03 December 2009

Arboricultural Officer

Planning Application BR/273/09/T remove

grind stump of 2 common Beech trees & reduce crown by no more than 15% of 1 Common Beech. Reduce crown by 2 metres & remove lower epicormic growth to one Walnut tree, at 106 Chichester Road Bognor Regis PO21 5AA.

Photograph 4: View of T4 from the South

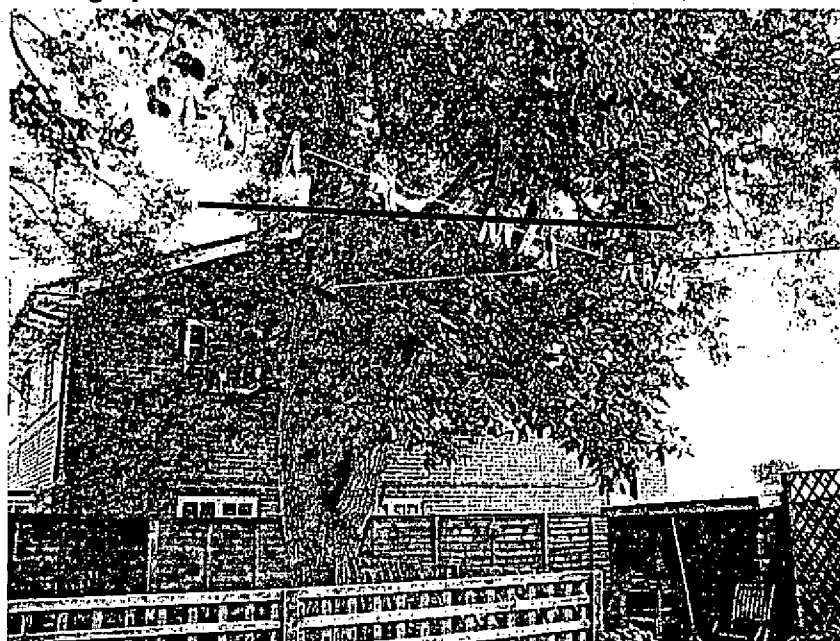
T4 agree the pruning back of the Walnut from the adjoining property, but see no reason to remove the Epitomic growths from the main trunk. (Work on this tree must only be done between Late May & Early September. Walnuts bleed if work is done outside this time window.)

Drawing Title:
Tree Location Plan
106 Chichester Rd
Bognor Regis

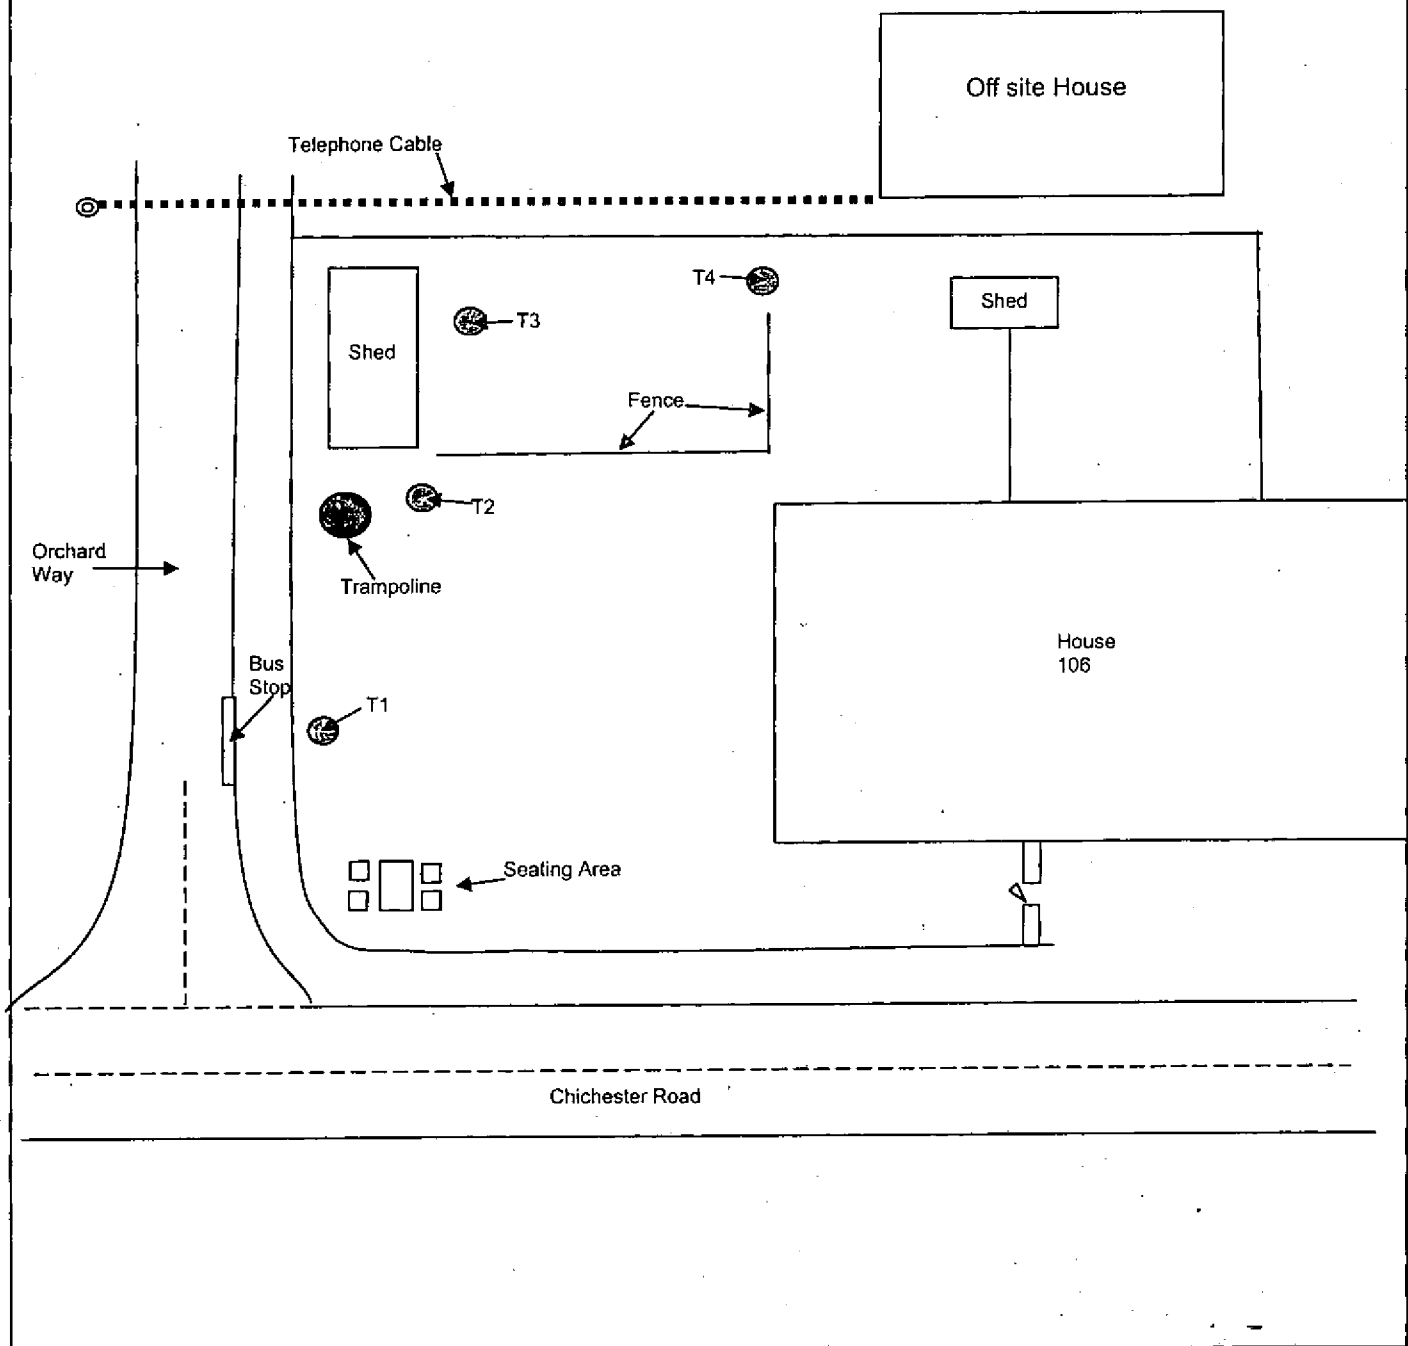
T2 agree with 15% reduction.

T3 only a very small area of fungal Infection was found at the base of the tree. I recommend refusal as there is no compelling evidence that the tree is in decline, and may well survive for 30-50 years.
